WEST SUSSEX COUNTY COUNCIL CONSULTATION

TO:	Arun District Council FAO: Mrs A Gardner
FROM:	WSCC - Highways Authority
DATE:	19 May 2021
LOCATION:	Paddock House 44 Ferringham Lane Ferring BN12 5LU
SUBJECT:	FG/50/21/PL Variation of condition approved under FG/115/17/PL relating to condition 2-plans condition. This site is in CIL Zone 4 and is CIL Liable as new dwellings.
DATE OF SITE VISIT:	n/a
RECOMMENDATION:	Advice
S106 CONTRIBUTION TOTAL:	n/a

2020-6201-005

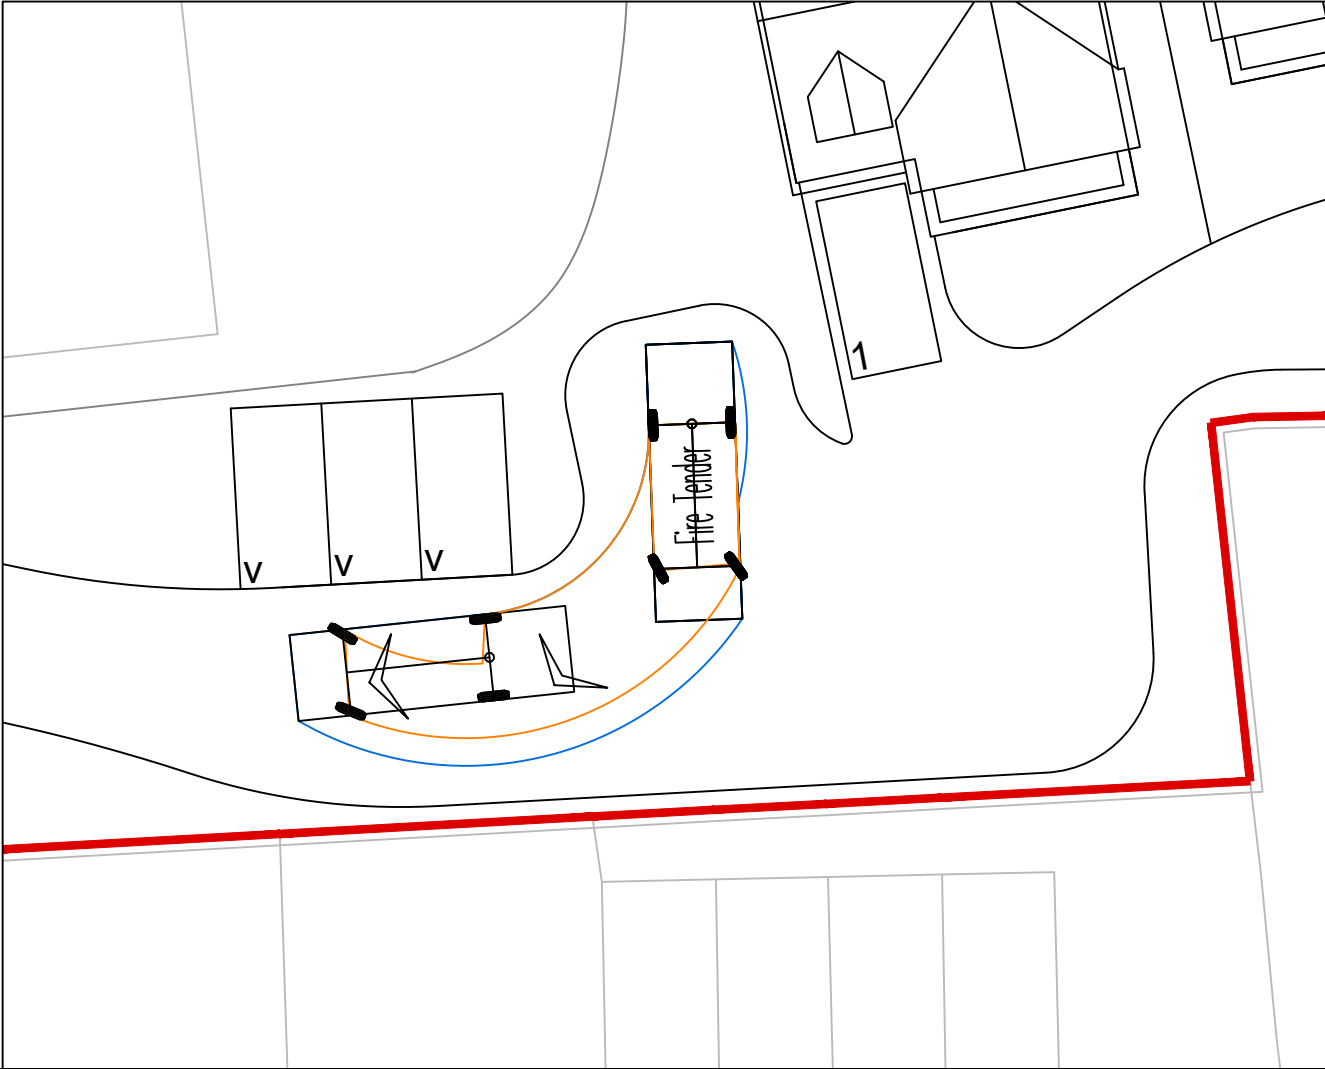
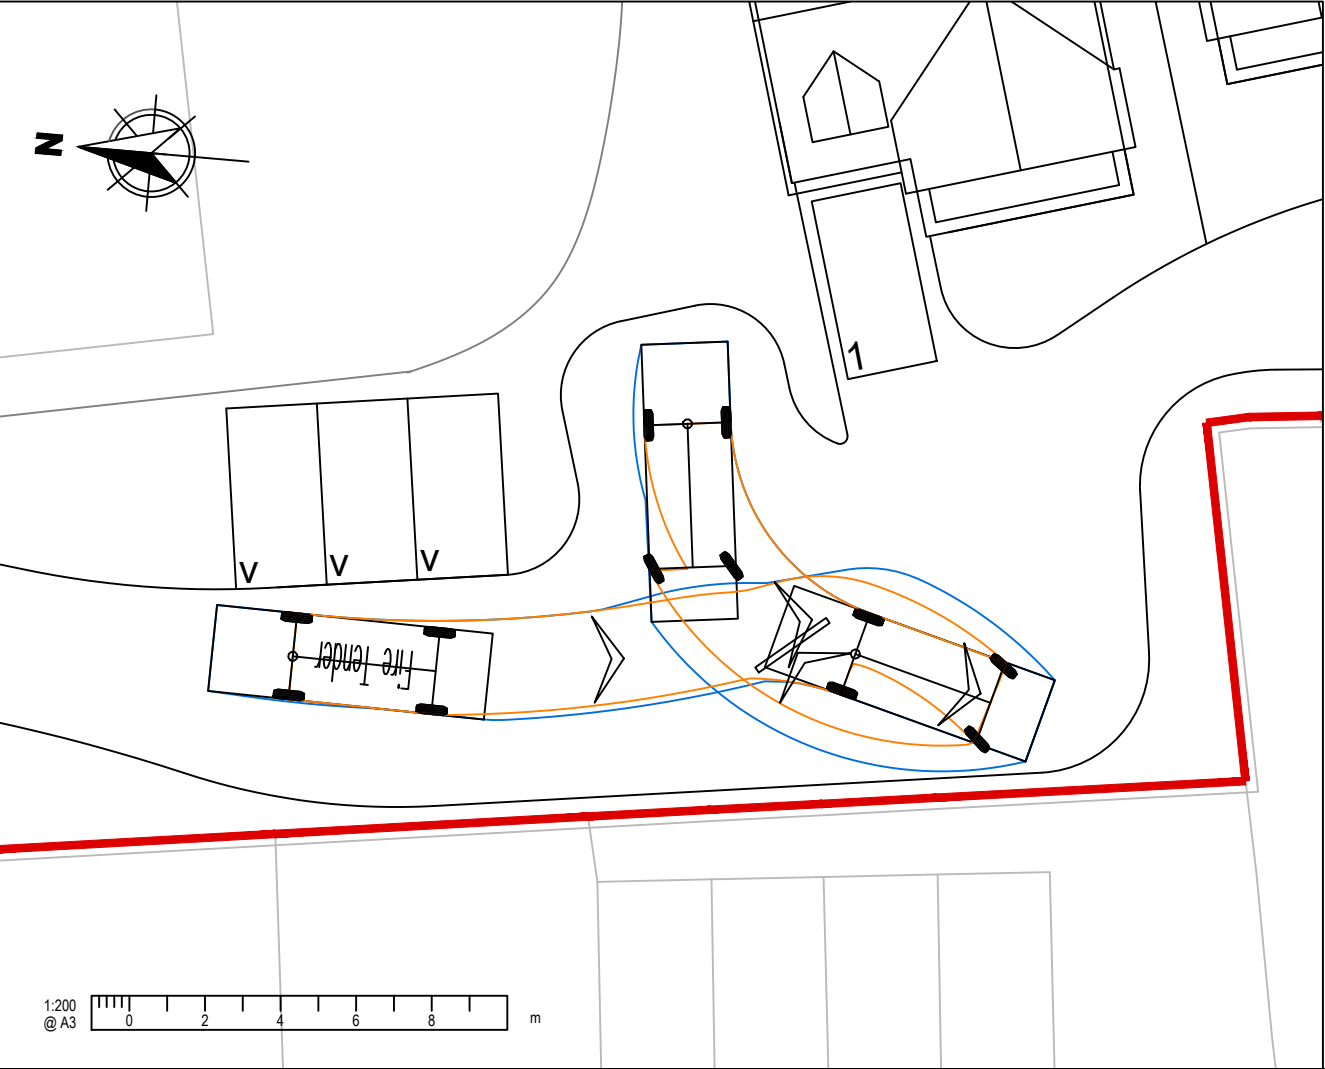
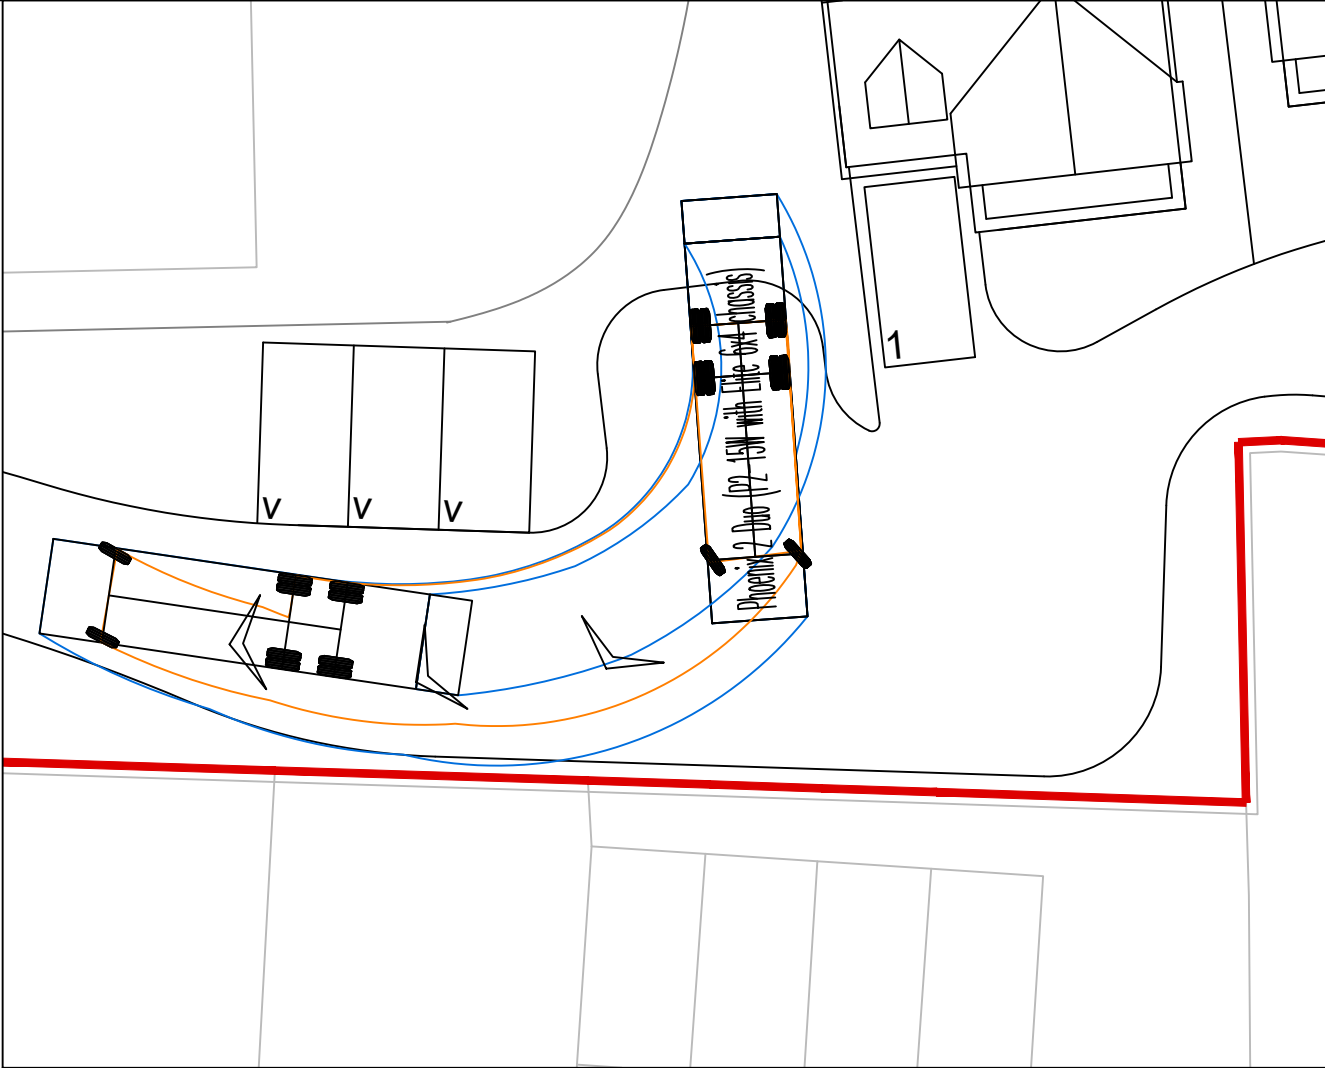
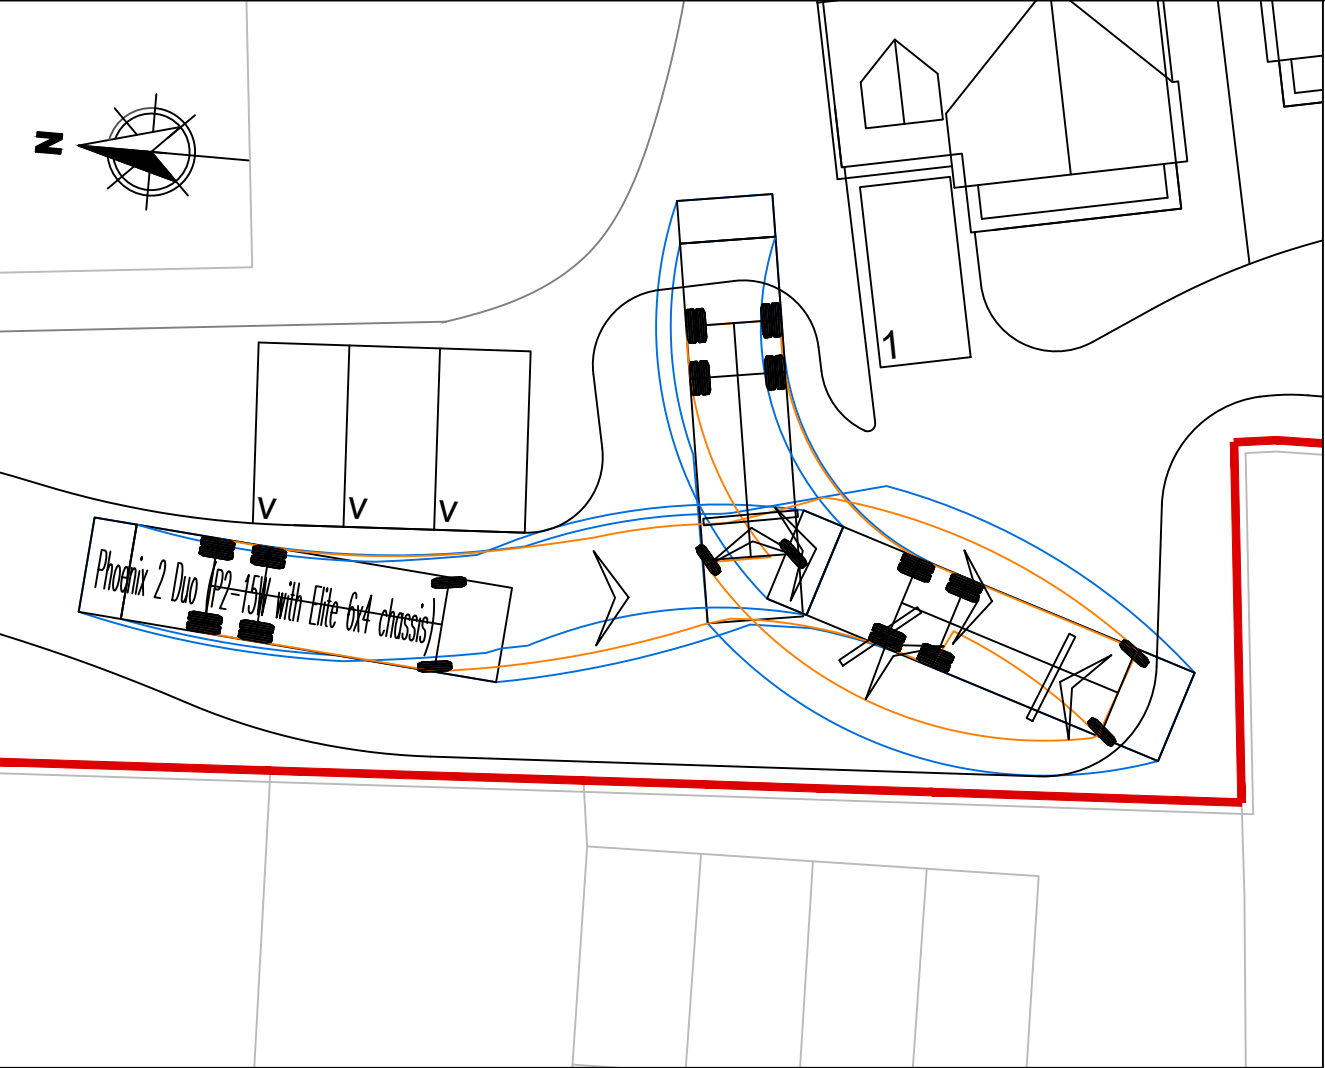
The applicant has now submitted swept path tracking plans (2020-6201-005) and while the reference numbers do not match those annotated on the site plan it is clear that the area is of a similar geometry and that a fire tender and refuse vehicle will still be able to turn within the confines of the site.

No highways concerns would be raised to this variation of condition application.
